Your ref:
Our ref: 22/00770/F
Please ask for: Miss Sandra Homcenko
Direct dial: 01553 616824
E-mail: borough.planning@west-norfolk.gov.uk

Details: **RETROSPECTIVE APPLICATION: A single storey extension to the rear of the bungalow.
at Three Trees 21 Graham Drive Middleton King's Lynn Norfolk**

Proposed new single storey extension
 21 Graham Drive
 middleton PE32 1RL
 Scale 1:100

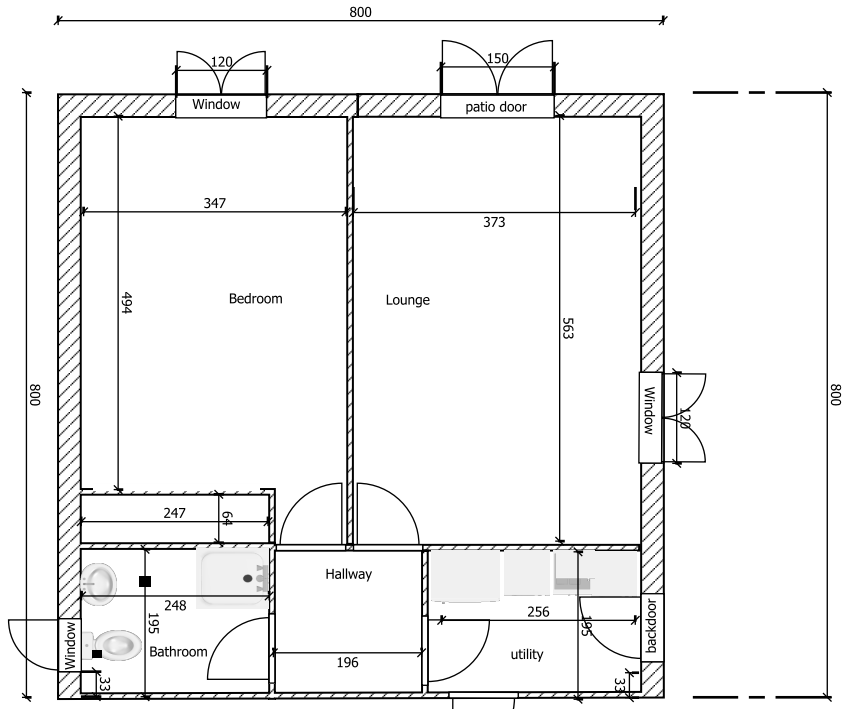
1. Please provide existing floor plans, existing elevations and existing roof plan.
Please provide proposed floor plans, proposed elevations, and proposed roof plan separately.

Please title your plans for clarity, for example: "existing floor plan"; "proposed side elevation"
2. In accordance with the National Validation Checklist, which became mandatory on 6 May 2008, we will require information regarding site levels. If site levels are to change, please provide four copies of a site survey drawing, alternatively, if site levels are to remain unchanged, this can be annotated on the relevant plan or advised in writing.
3. Please confirm if you agree to change the description to: "A single storey extension to the rear of the bungalow"
4. Please confirm scaling on your block plan, this should be done to either 1:200 or 1:500
5. Please revise your floor plans, it appears that door details have been drawn instead of windows, please amend
